Your ref:	Accessorize 433 Strand	Please reply to:	Mr Gregor Gault
Our ref:	23/07107/ADV	Tel No:	
		Fee Queries:	0207 641 6500;
		Email:	planningreception@westminster.gov.uk;
Miss Melanie Fernando 1 Nicholas Road Nottinghill Village London W11 4AN England		Incomplete Applications Town Planning & Building Control City of Westminster PO Box 732 Redhill, RH1 9FL	
		23 October 2023

Address: 443 Strand, London, WC2R 0QU,

Proposal: Display of an internally illuminated fascia sign measuring 51cm x 519.5cm.

EXISTING  
AND SIGNAGE  
**AS BUILT**

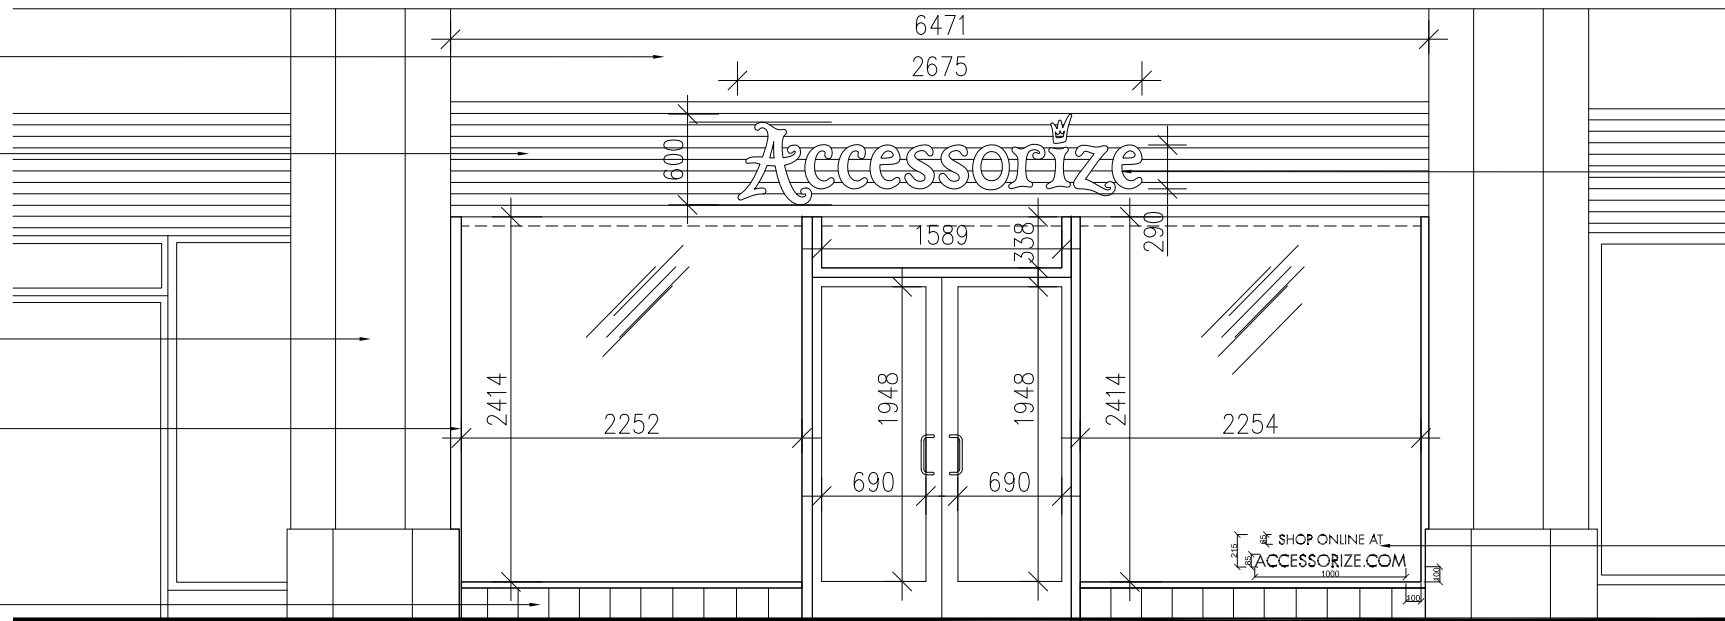
- 1 Please provide metrically scaled existing elevation and section drawings.
 - 2 Please provide a detailed section drawing showing the method of illumination for the proposed sign.
- 0 *Please collate all requested information in a single submission and send to planningreception@westminster.gov.uk. Sending your documents individually will not speed up the process. Please do not upload to the planning portal as this causes duplication and may delay the processing of your application. Thank you.*
